I do not believe that adequate provision has been made to minimise the adverse impacts of the Albion Park Bypass on agriculture – particularly at “Meadowview” – a dairy farm on the Illawarra highway located south-west of the current Princes Highway/Illawarra highway intersection.

“Meadowview” is a highly productive dairy farming operation. While the bypass will impact on Meadowview in many ways, I am particularly concerned by two aspects of RMS’s proposal;

# Map 3 - Southern Interchange

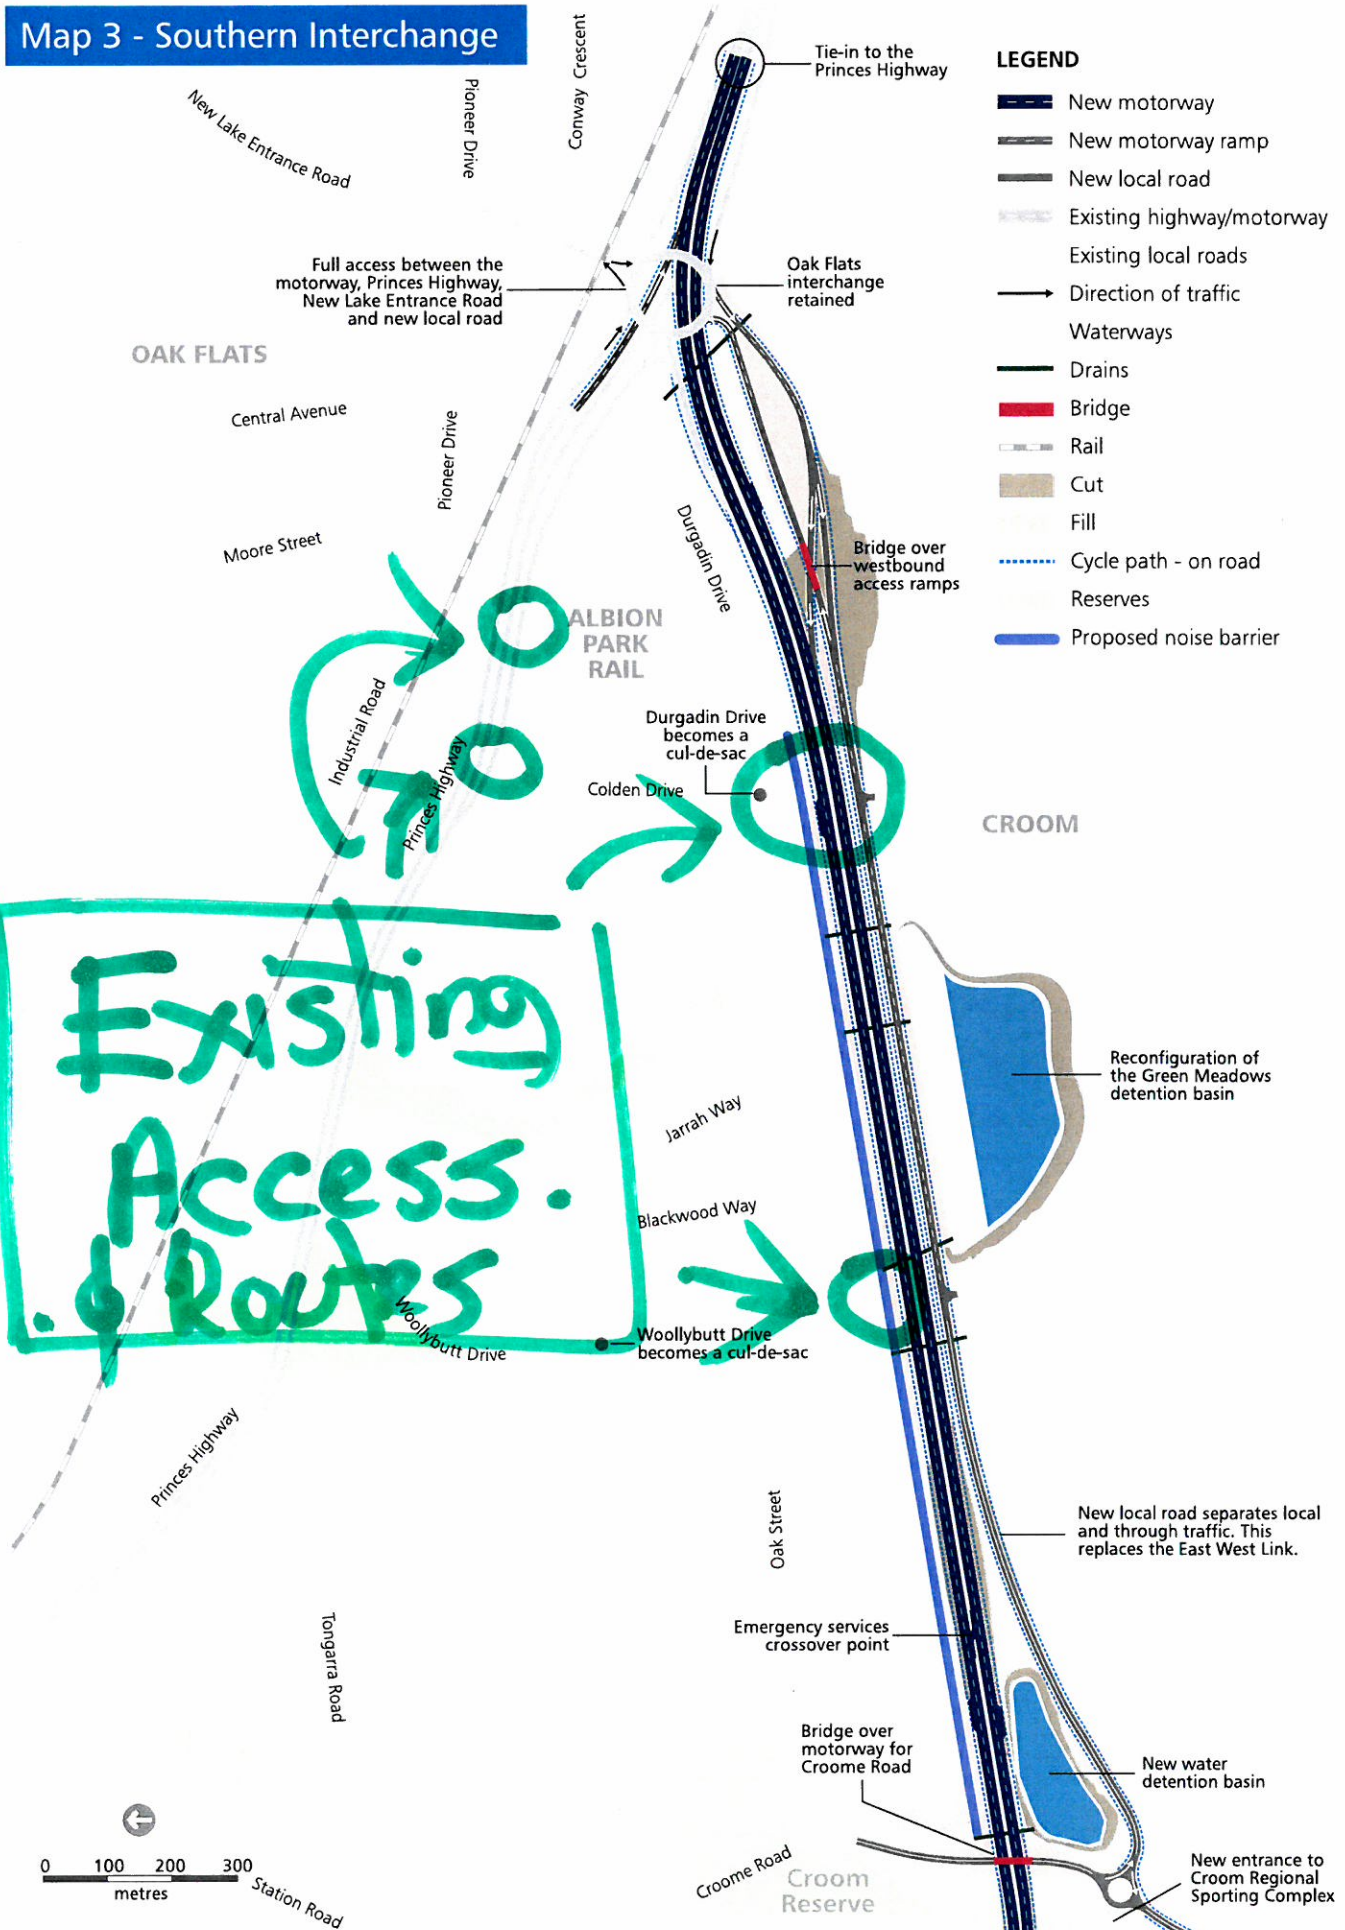
1. The proposed route (opposite the Illawarra Highway/Croome Lane intersection) will take the limited amount of high ground at Meadowview and include the demolition of the farm’s sheds, milking shed, feedpad and the farmer’s family home. The location of this type of farm infrastructure on high ground is vital to the productivity and viability of a dairy farm. Much of Meadowview is vulnerable to flooding and unsuitable for this type of farm infrastructure. I encourage RMS to revise the route of the bypass to enable the preservation of the limited amount of high ground available for dairying at “Meadowview” – the current location of the farm sheds, milking infrastructure, feed pad and family home is vital as these buildings cannot be moved to lower lying land that is vulnerable to flooding. To proceed with the current proposed route would result in an unreasonable adverse impact on agriculture and dairying.

2. “Meadowview” is vulnerable to flooding. The Environmental Impact Statement states that the Illawarra Highway at Frazers Creek floods seven times per year. The bypass in its current plan is likely to decrease the drainage of flood waters from Meadowview towards the Macquarie Rivulet, resulting in paddocks that retain excess water for longer. Excessively wet paddocks cannot be grazed and this obviously has an adverse impact on a dairy farm. I encourage RMS to increase the use of bridging in the vicinity of Frazers Creek. The bypass should be built in a manner that enables Frazers Creek and surrounding paddocks to continue to drain at their current rates. To build a bypass that inhibits the drainage of flood waters will adversely impact both agriculture and the local environment.

I encourage RMS to make changes to the plans for the Albion Park bypass to provide for minimal adverse impact on agriculture and the ongoing viability of the Meadowview dairy farm. The current RMS plans fail to acknowledge the importance of the limited amount of high ground at Meadowview to agriculture – this high ground should be preserved for dairying. The current RMS plans also fail to address the adverse impact of the bypass on future flood waters at Meadowview – unimpeded drainage of flood waters is important to the productivity of Meadowview.
